5 June 2026

Proposal: Concurrent rezoning and State Significant development application for the construction of one build-to-rent apartment building and two build-to-sell apartment buildings over a podium, the development includes infill affordable housing.

Property: 1-7 Burton Street, 3B-11 Loftus Street and 10-12 Gipps Street, Concord

Ref No: SSD-84962709

21/06/2025 2:00 PM

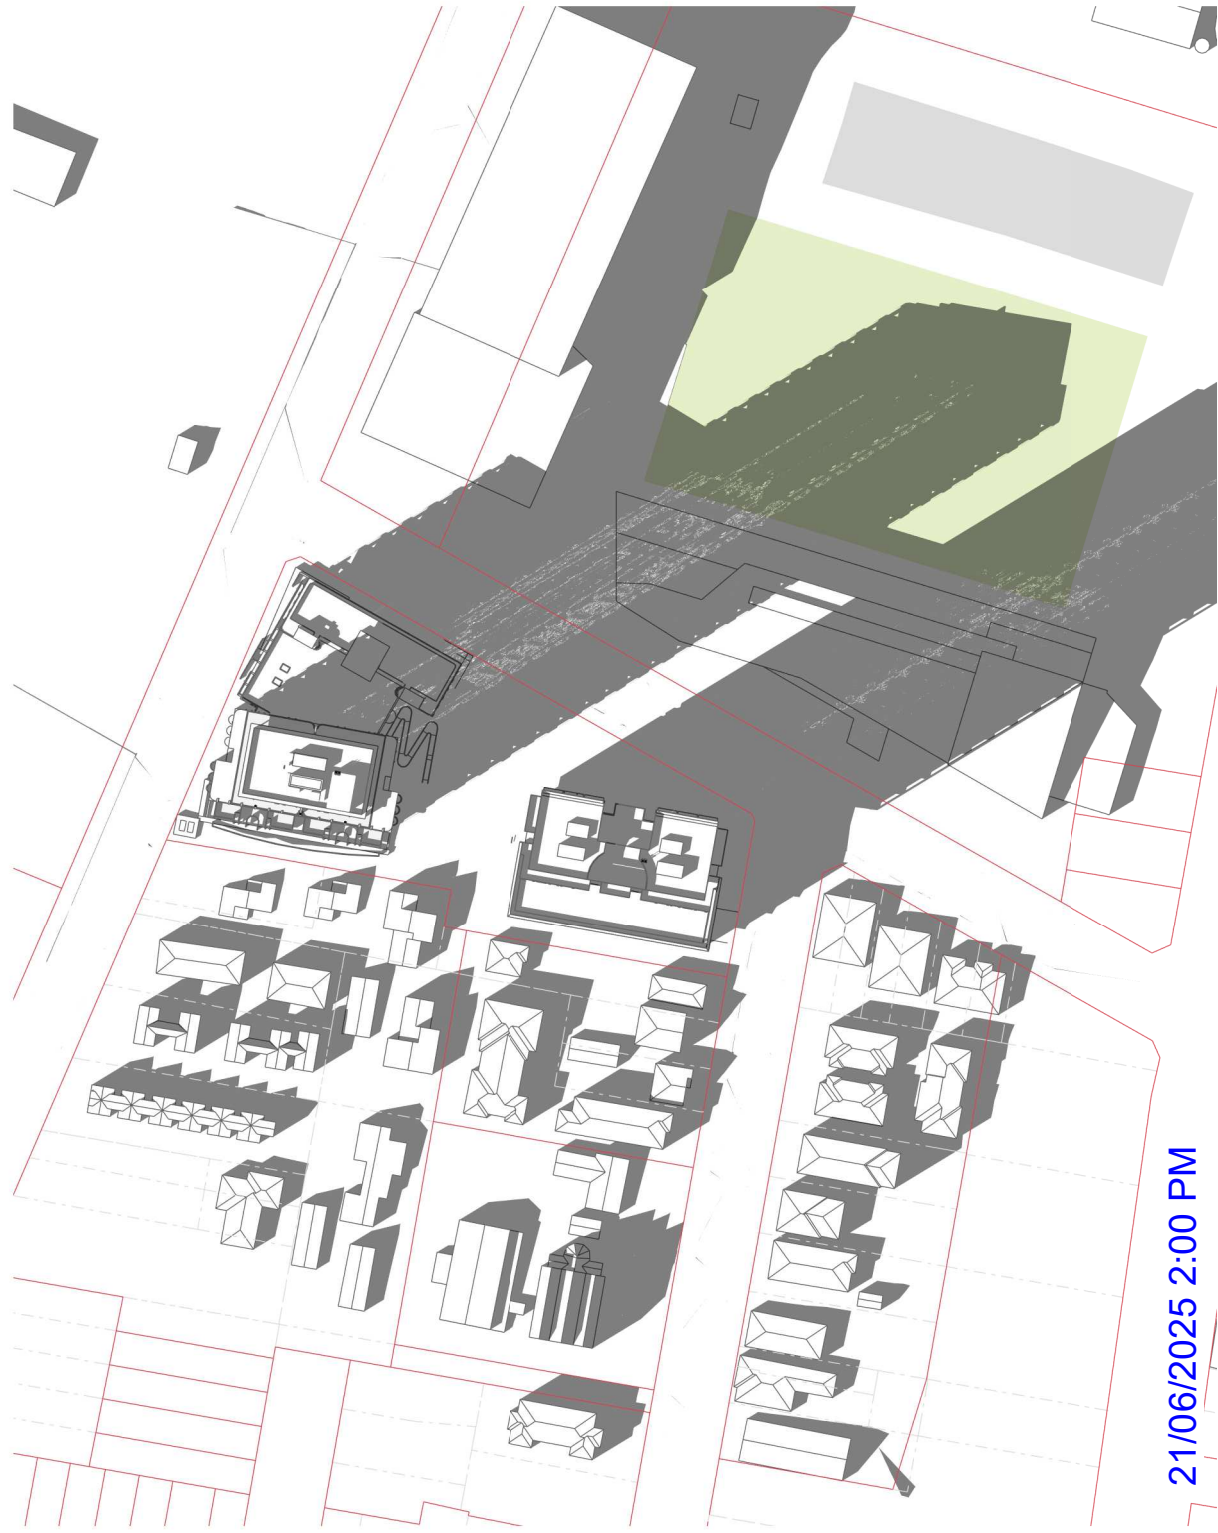
- The Burwood North Metro Urban Design Framework states “*Protected Open Space Requirements: Concord Oval shall not have any additional overshadowing of the playing surface from any adjacent development.*” Additional overshadowing of the playing surface from 1pm onwards at mid-winter is shown in the shadow diagrams. See further discussion below.

The proponent's scheme, ranging from 23 to 29 storeys with a significantly higher FSR, substantially exceeds this envelope and results in additional mid-winter overshadowing of the playing surface (See figure 2). Independent agronomic review confirms that this increase in shadow would adversely affect turf health, resilience and the safe use of the facility, particularly during periods of peak winter use.

- the proposal be updated and amended to demonstrate that there will be no additional overshadowing of Concord Oval between, at least, 11am and 2pm in mid-winter.

Drawing / Oval Overshadowing

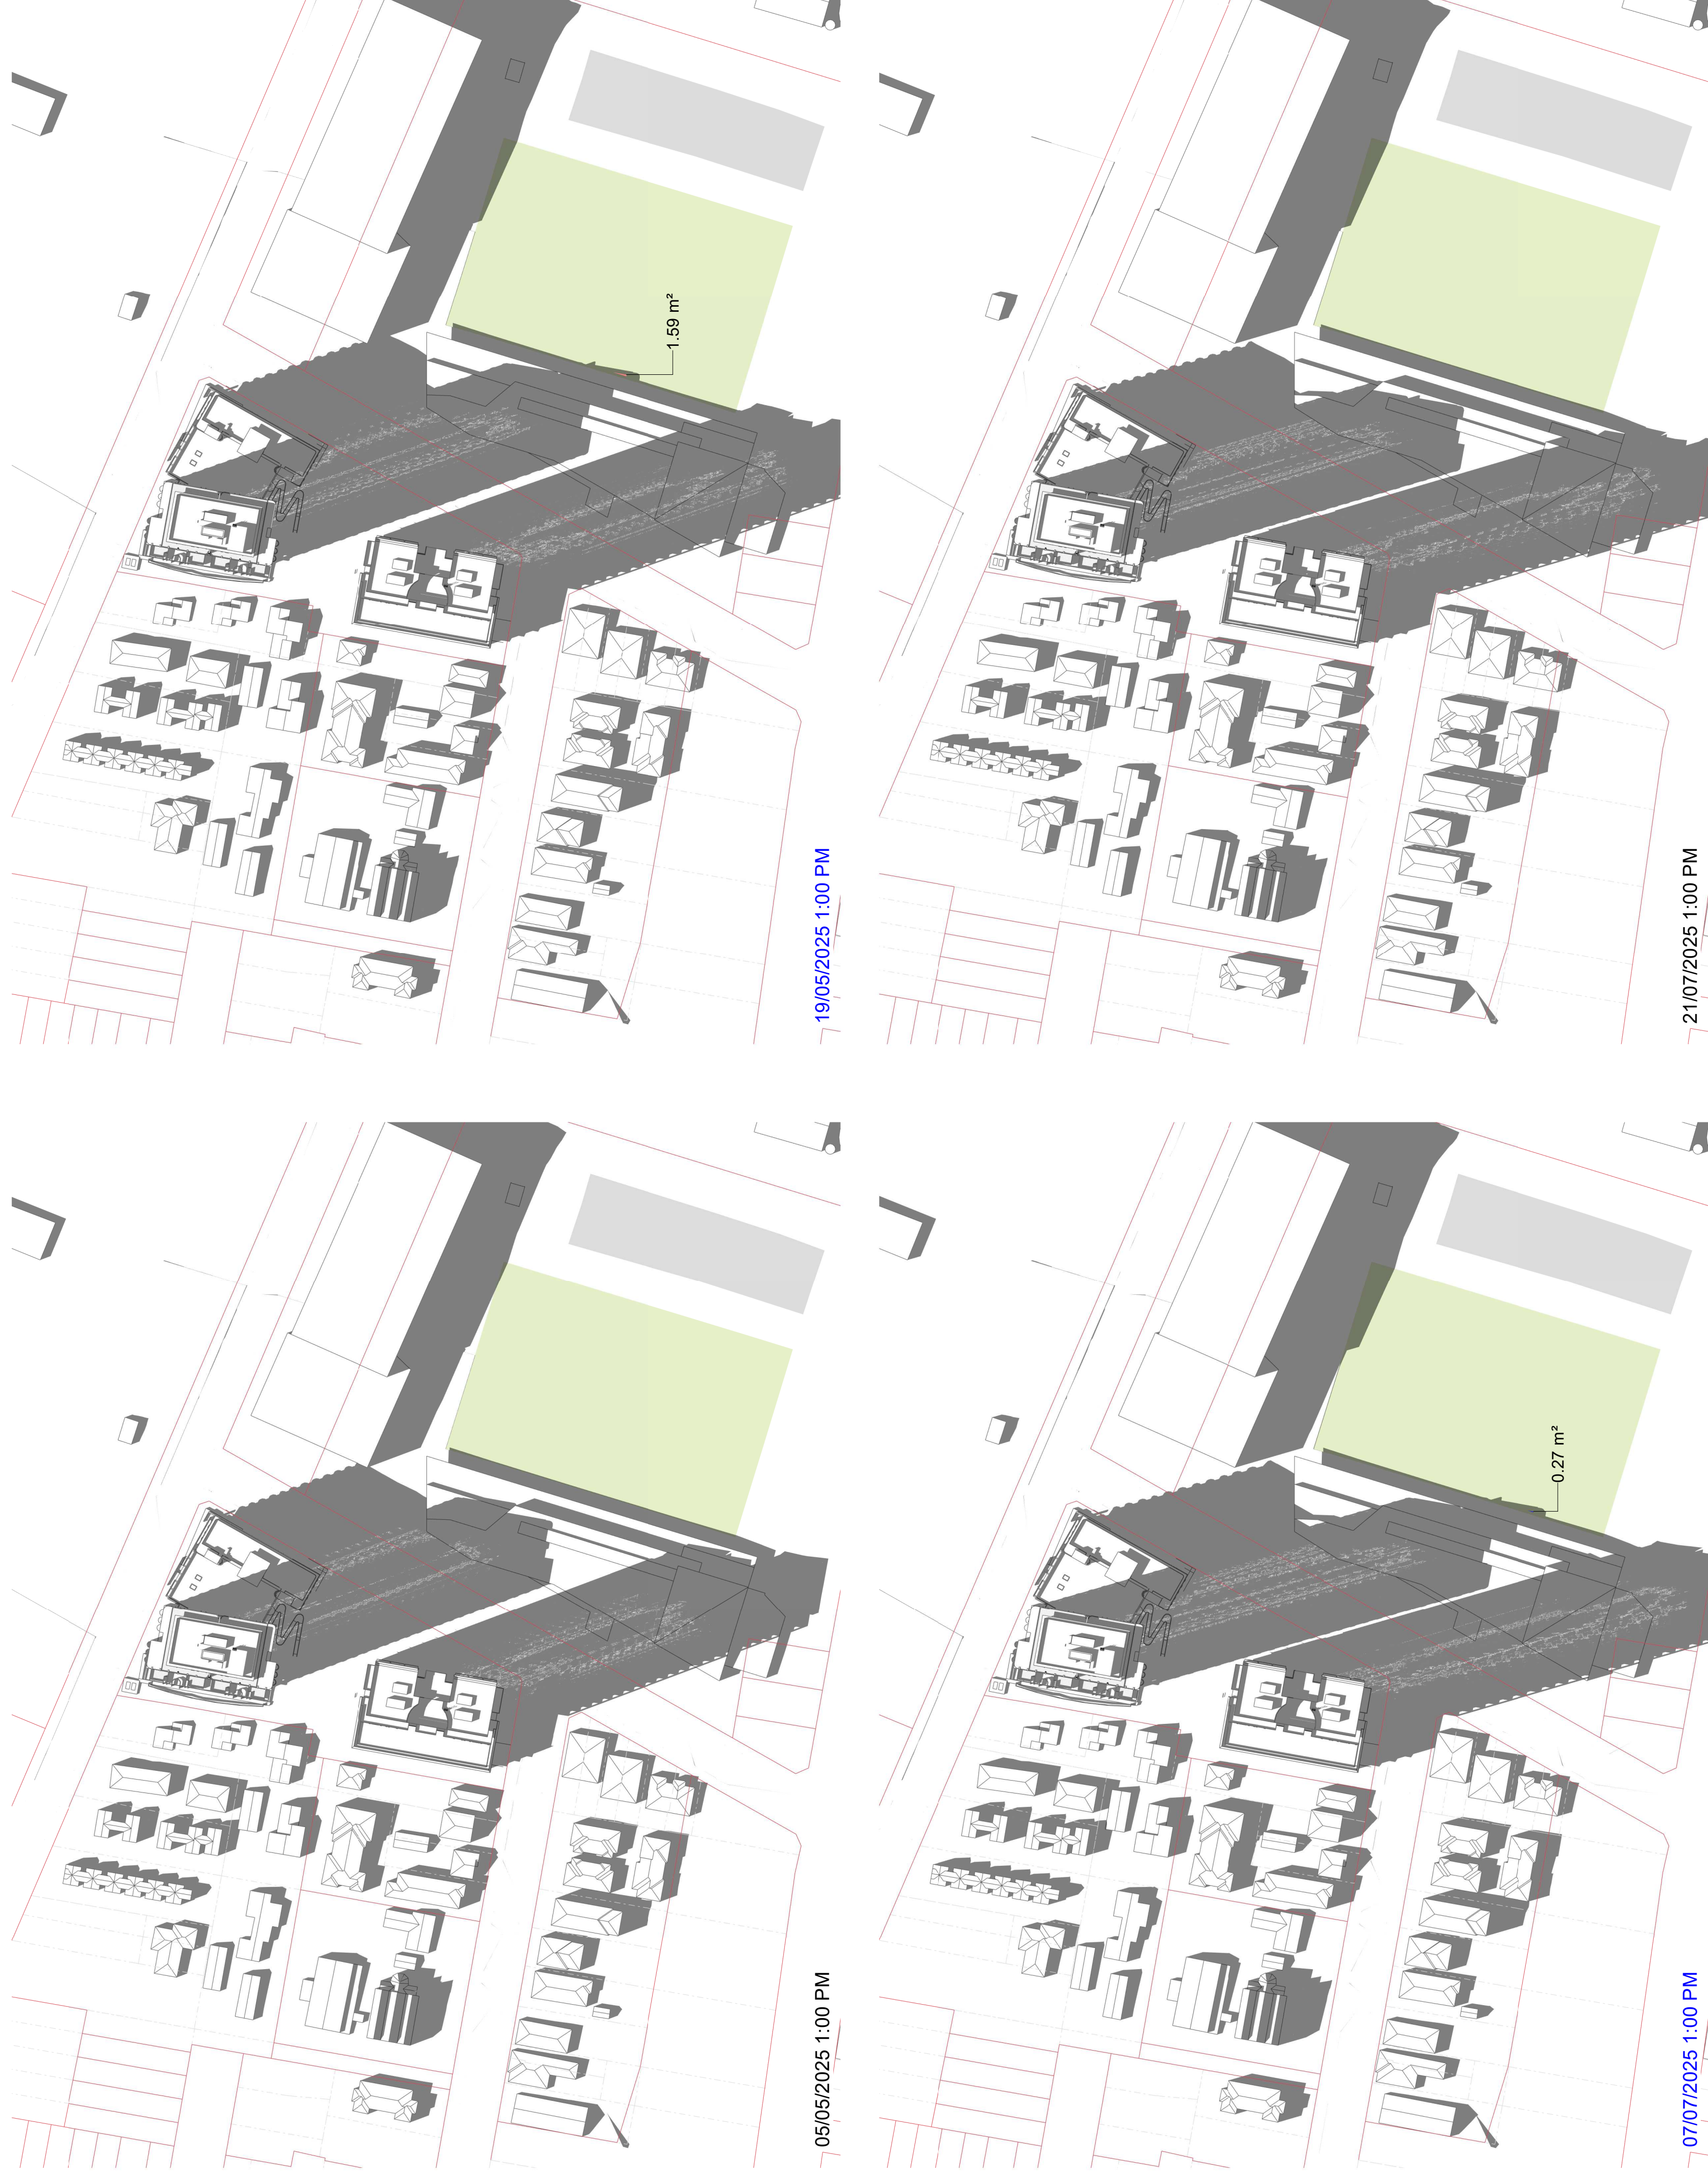
The SSDA & EIS do not meet these requirements.
